From: Paul Cann <Paul.Cann@arun.gov.uk>
Sent: 13 September 2021 10:04
To: Planning.Responses <Planning.Responses@arun.gov.uk>
Cc: Sarah Burrow <Sarah.Burrow@arun.gov.uk>
Subject: RE: Planning Re-Consultation on: BN/99/21/DOC

Engineers comments;

Application No: BN/99/21/DOC
Registered: 22nd July 2021
Site Address: Barnham Court Church Lane Barnham PO22 0BP
Grid Reference: 495577 103572
Category: Discharge of Condi
Description of Works: Approval of details reserved by condition imposed under BN/62/20/HH relating to condition 3-surface water drainage.

DRAWN BY	CHECKED BY	DESIGNED BY
PF	JL	JL
SCALE @ A1	© DATE	STATUS
1:100	July 2021	Planning
JOB NO.	DRAWING NO.	REVISION
31789	EX.01	P2

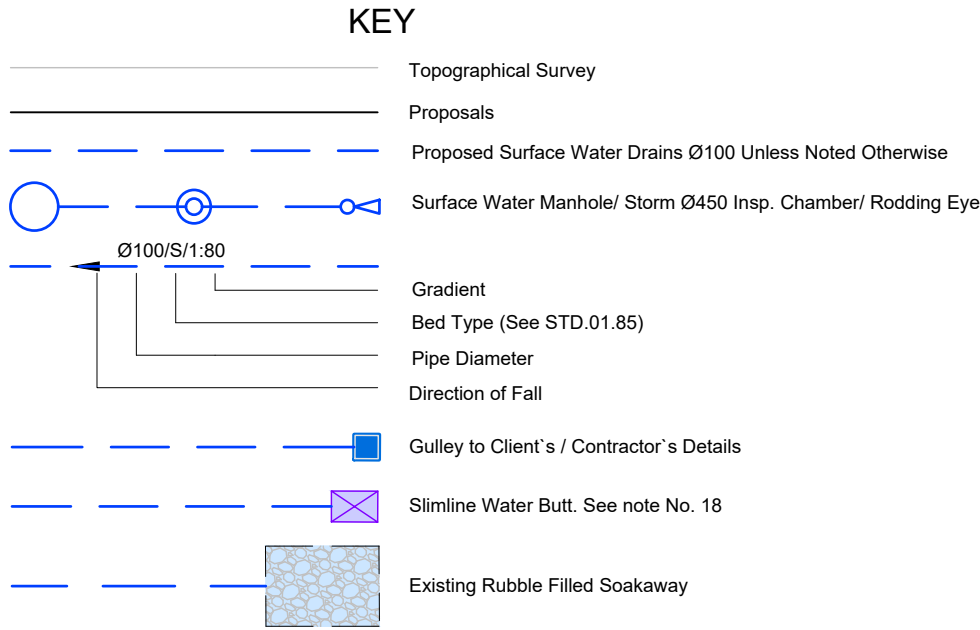
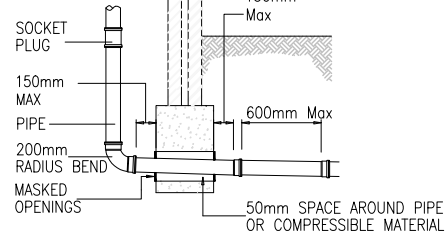
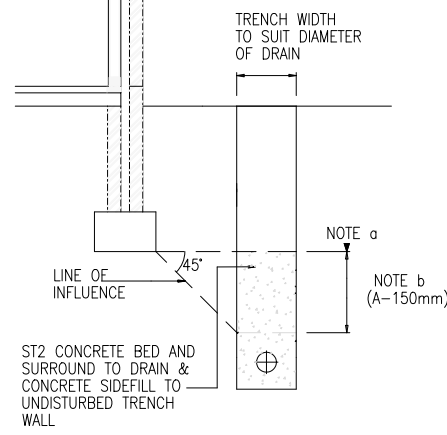
1. Confirmation is required as to the extent of the drainage system that has been constructed. Of that constructed, the engineers will need to produce an 'as constructed' drawing. From a site inspection, it would appear that the overflow pipe has not yet been connected to the ditch and has been laid up to the existing trackside hedgerow. Please note that remedial works may be required but this is dependent on the other matters below being resolved/considered.

2. There is some doubt as to whether the pipe discussed above (between boundary wall and hedgerow) has been laid to the proposed gradient and certainly its bedding will need to consider item 3 below.

3. The entire length of the outfall pipe between the gully and the ditch will require concrete bed and surround due to minimal cover and the risk of root intrusion, etc.

5. Has the proximity of the soakaway to existing and proposed buildings been considered in terms of the possible effect on foundations? This is critical to the whole scheme.

6. Gutter leaf guards are required to reduce the risk of leaf matter blocking the orifices.
7. Clearly indicate manhole and gully cover levels.
8. Show all gully invert levels.

9. Specify all inlets/outlet invert levels to/from channel drains.
10. Indicate invert levels of all pipes connecting into the soakaway including the outlet.

11. Indicate gradients of all pipes and channels.
12. Gullies must have sufficient traps for silt collection or else additional silt traps will be required in the form of catchpit manholes.

13. Introduce a crate layer to the soakaway to provide a means to formally connect pipework into the structure.
14. The pipework arrangement within the manhole in the SE corner is acute and needs reconfiguring.

15. Full construction details are required of all drainage elements.
16. Provide more details of the 'Freeflush' water butts ie. brochure/construction details. It also needs to be shown how the orifice connects to the outlet pipe.
